**Consultation Response from KC,
Conservation & Design**

2026/90657 6, Nelson Street, Dewsbury, WF13 1NA

Listed Building Consent for replacement of specified external doors and windows with like-for-like units (within a Conservation Area)

Date Responded: 1/5/26

Timber Sash Window Section Detail
Existing (1:5)

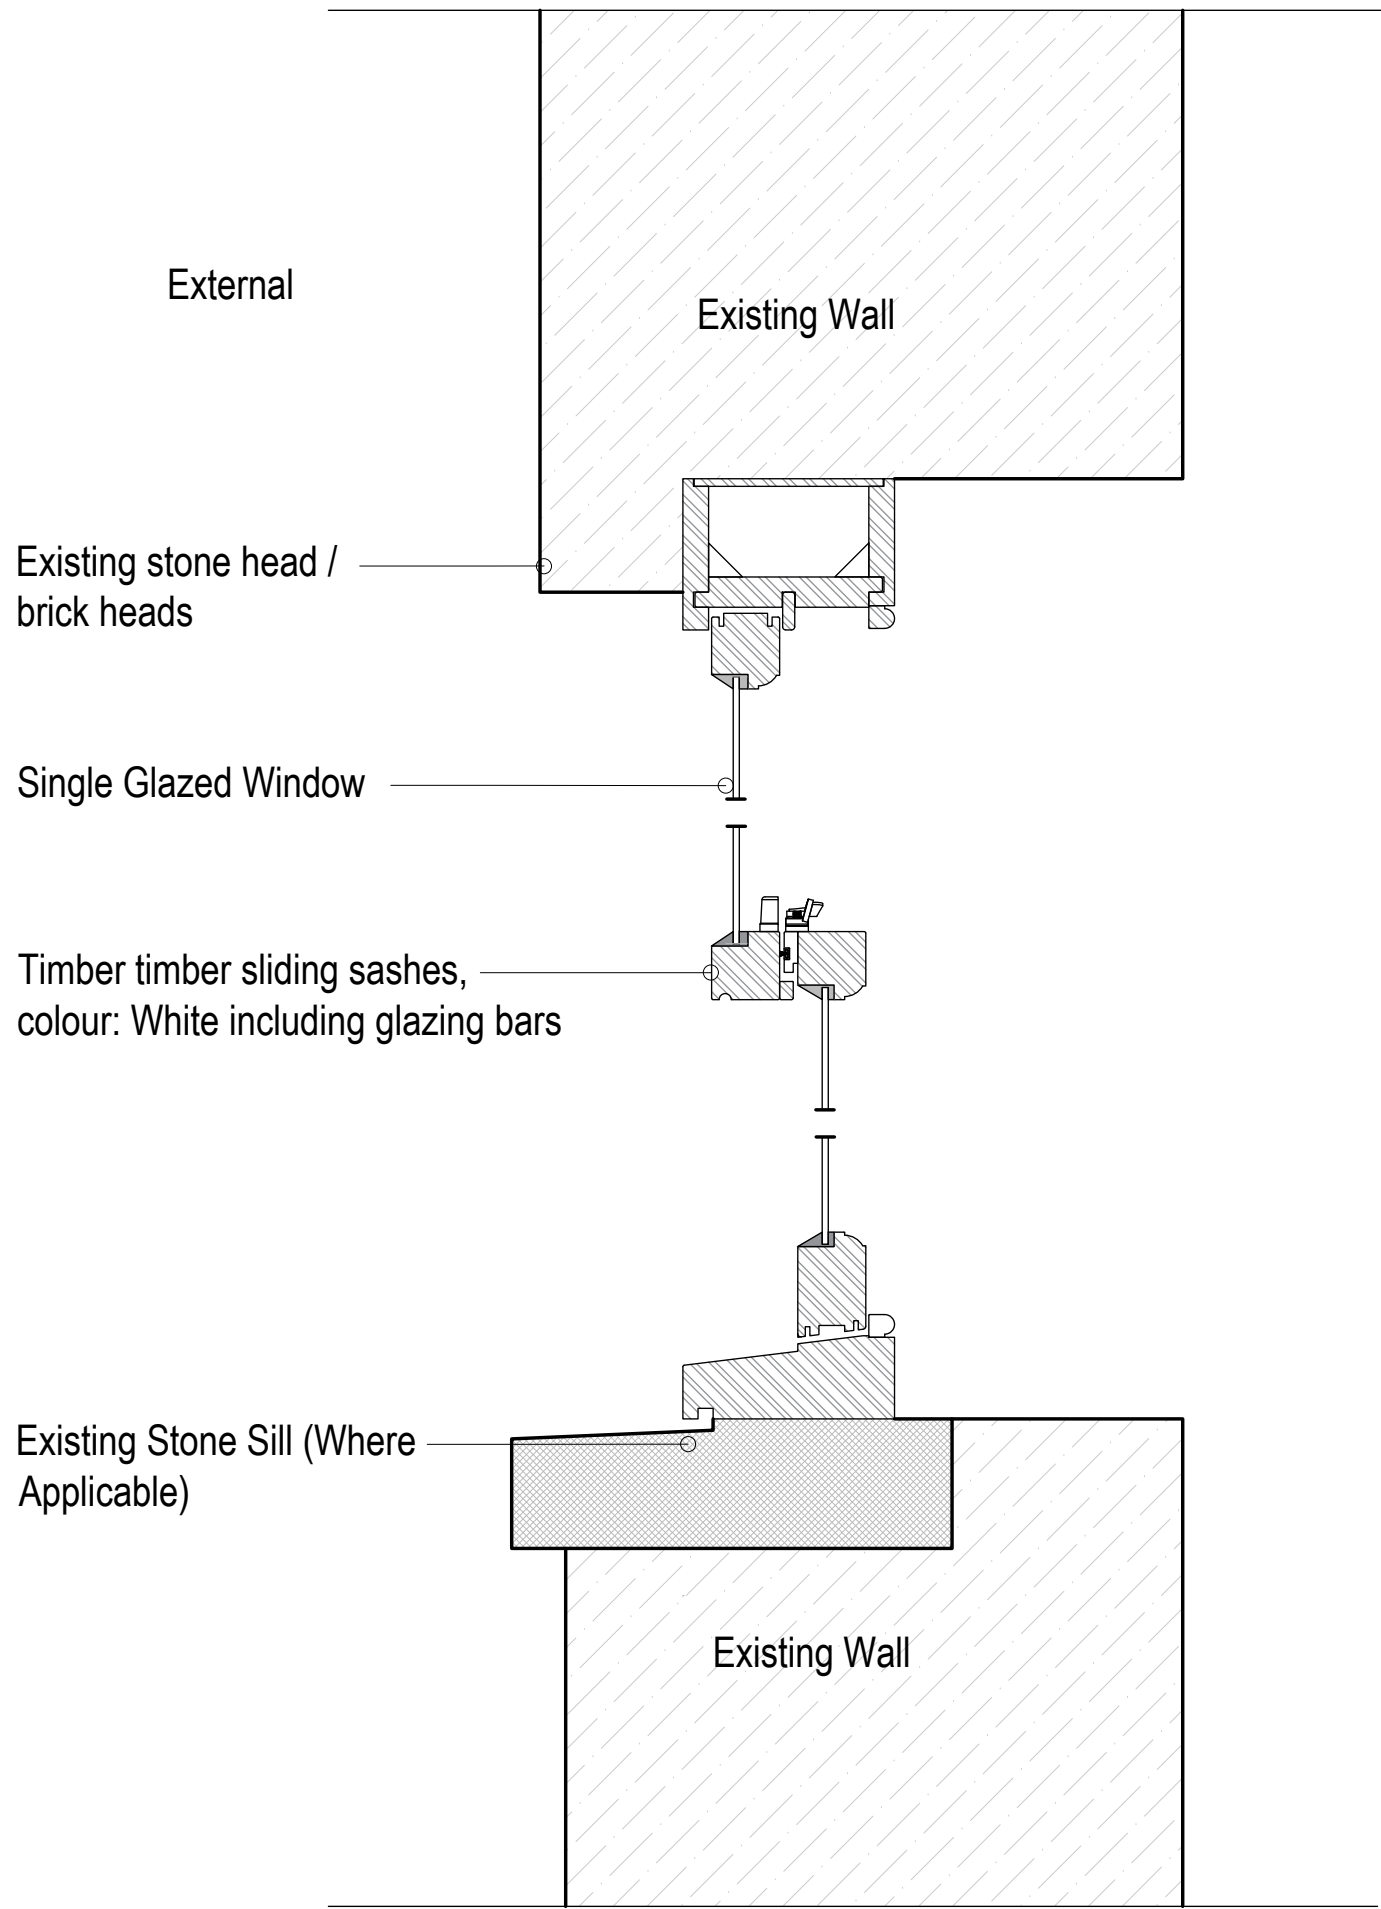
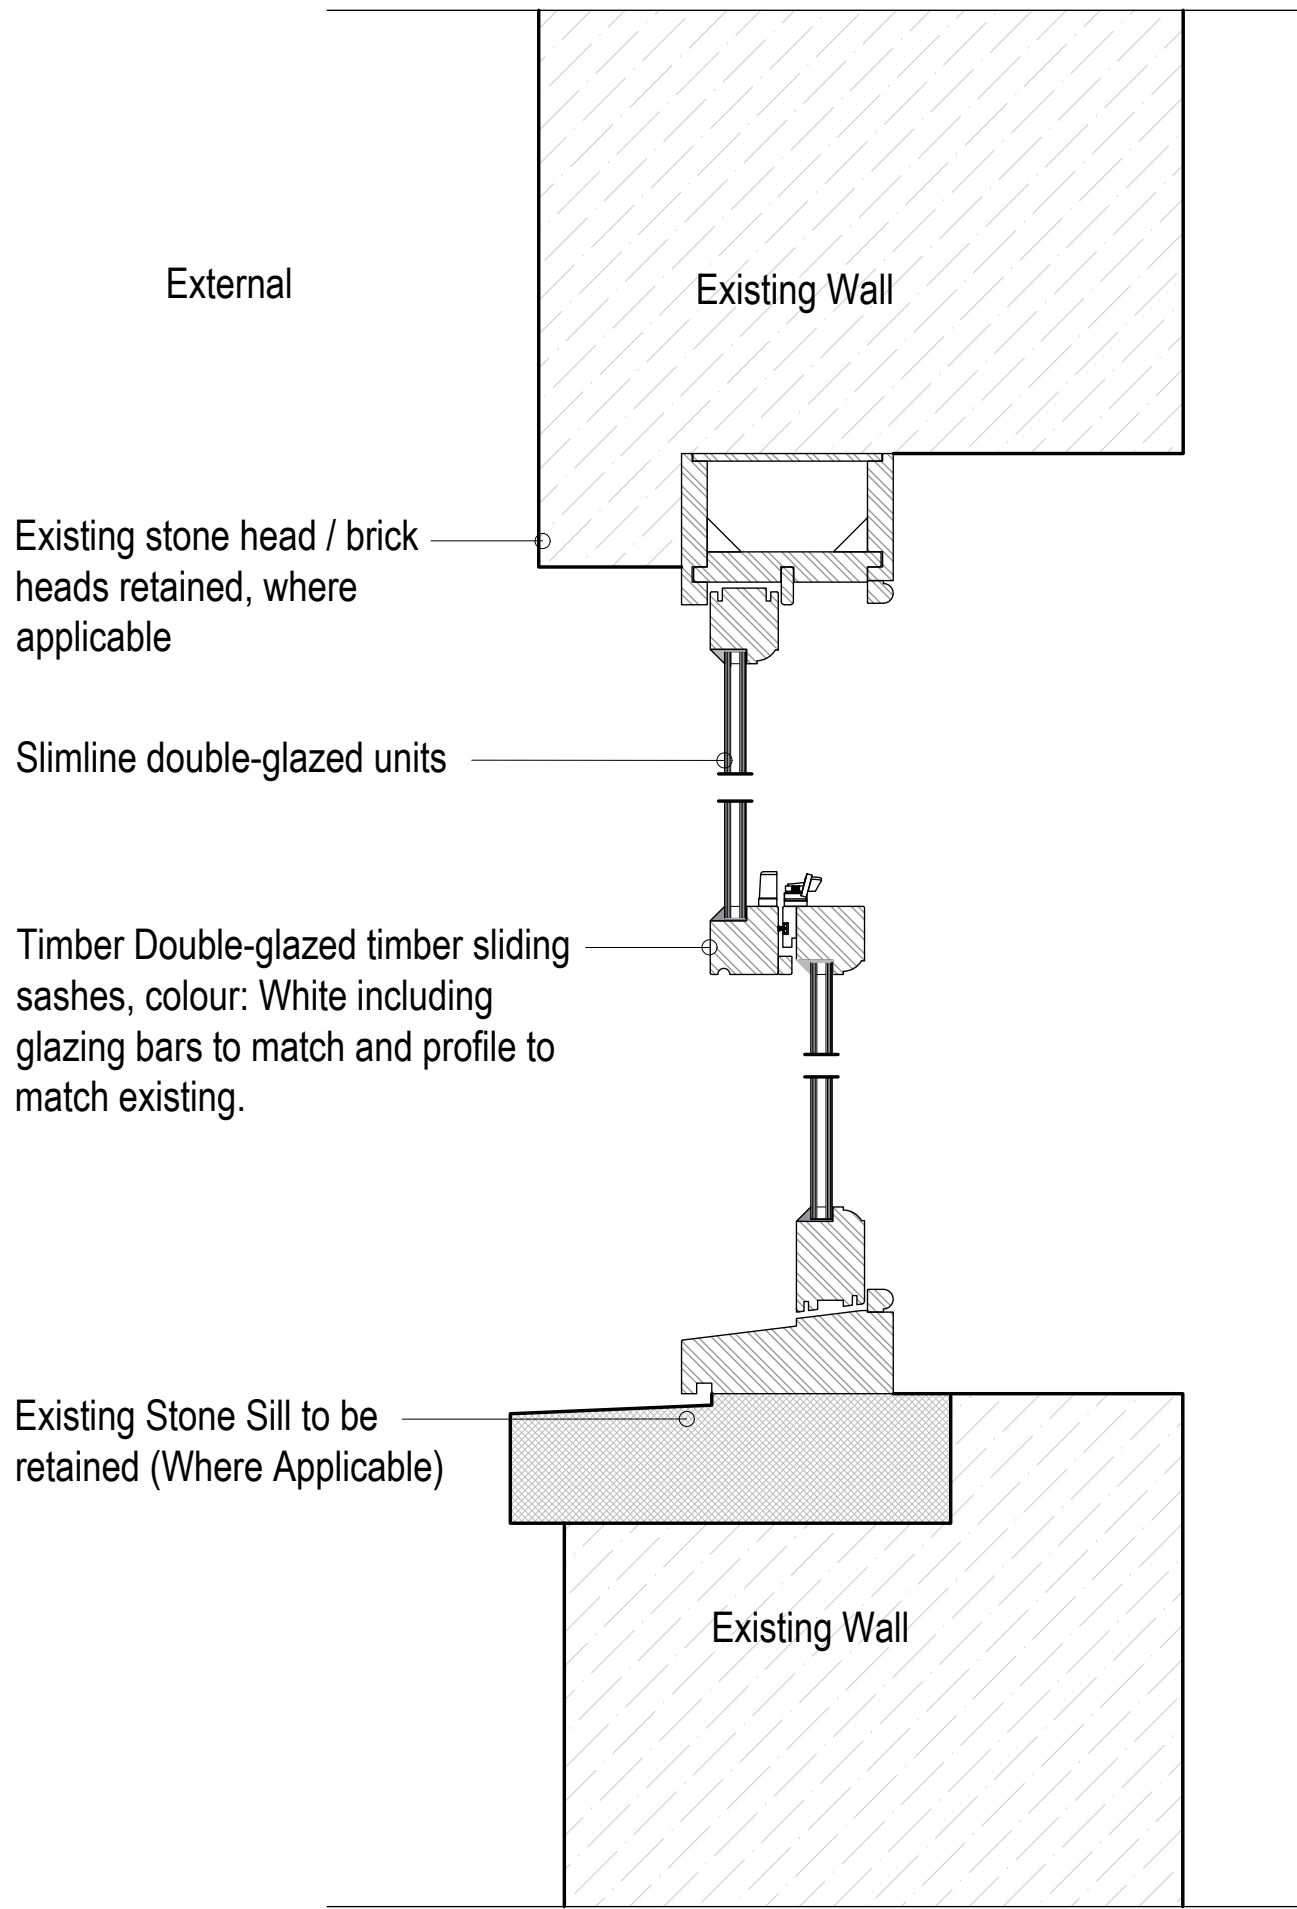
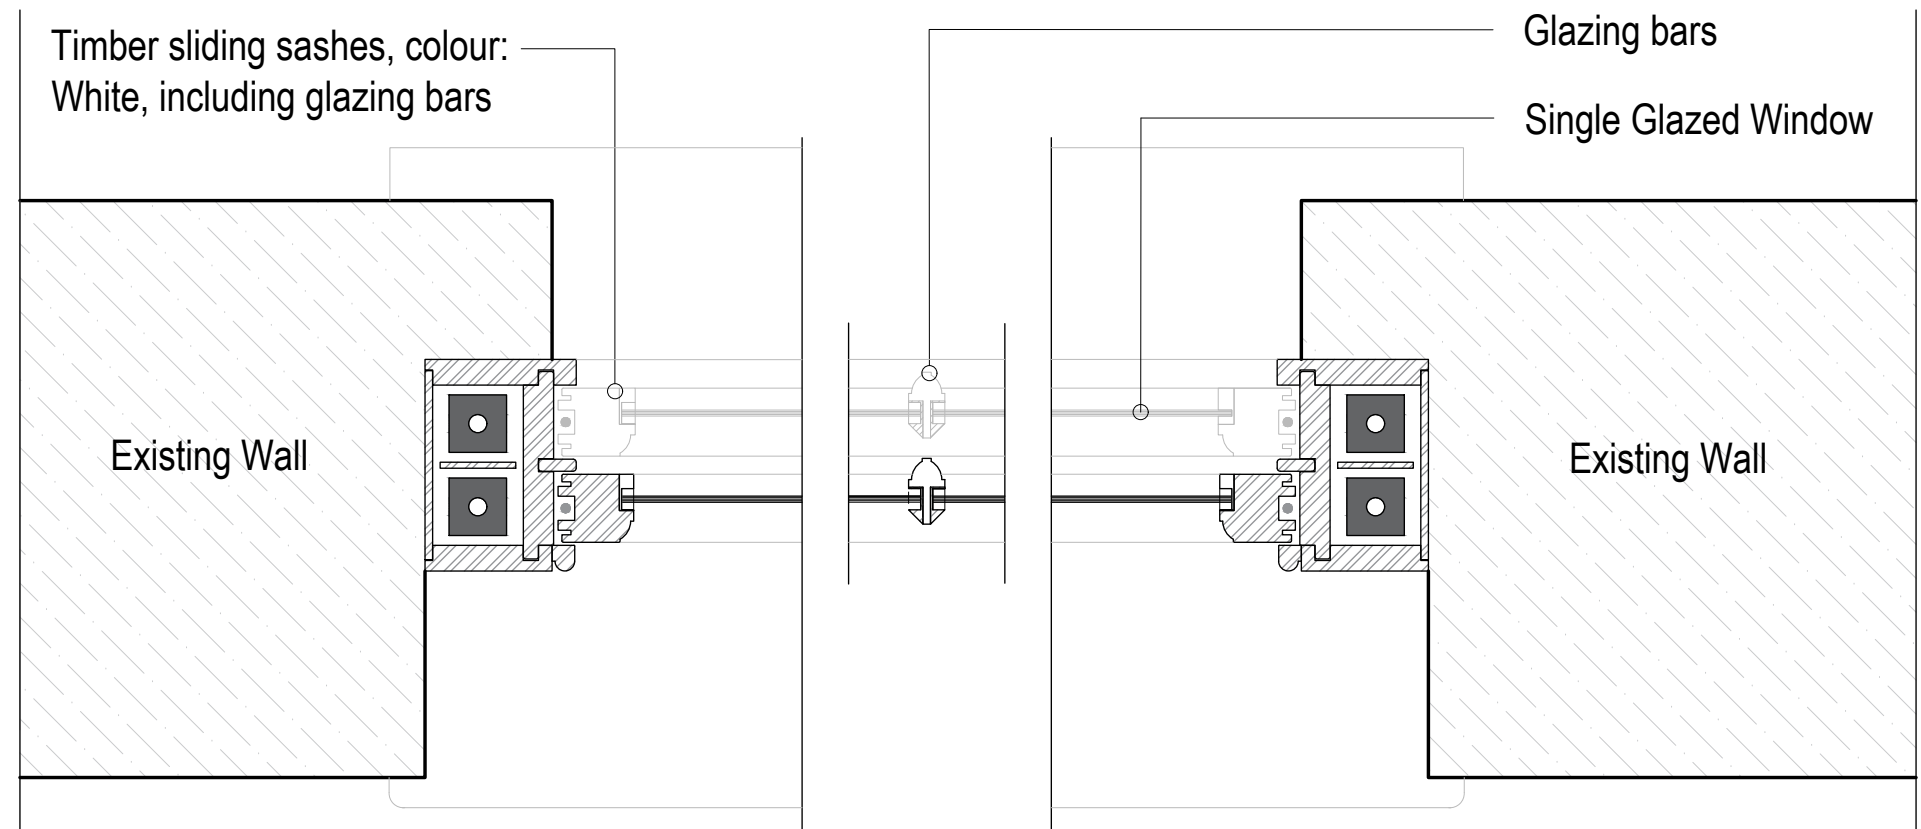
The new windows must replicate the existing as closely as possible by replicating the horn detail and mould profiles, frame depth, and set-back within the reveal, with traditional putty-faced glazing.

Slimlite double glazing is proposed and sections submitted stating 'frame thickness to match existing as closely as possible, thickness may vary (to be confirmed on site prior to manufacture and fitting).' A condition is to be imposed to ensure the details will be appropriate.

1. Notwithstanding the details provided, all windows shall match the existing joinery details in terms of material, profiles, detailing, dimensions, albeit with an increase in the internal section sufficient to accommodate slim double glazing. All slim double-glazed units shall have a maximum of 4mm glass with an 8mm gap with black spacer bars.

New opening windows shall be sliding sashes. Visible trickle vents shall not be permitted. All new window frames shall be set back in the reveal by 75-100mm or to match existing and shall not be fitted flush with the external wall.
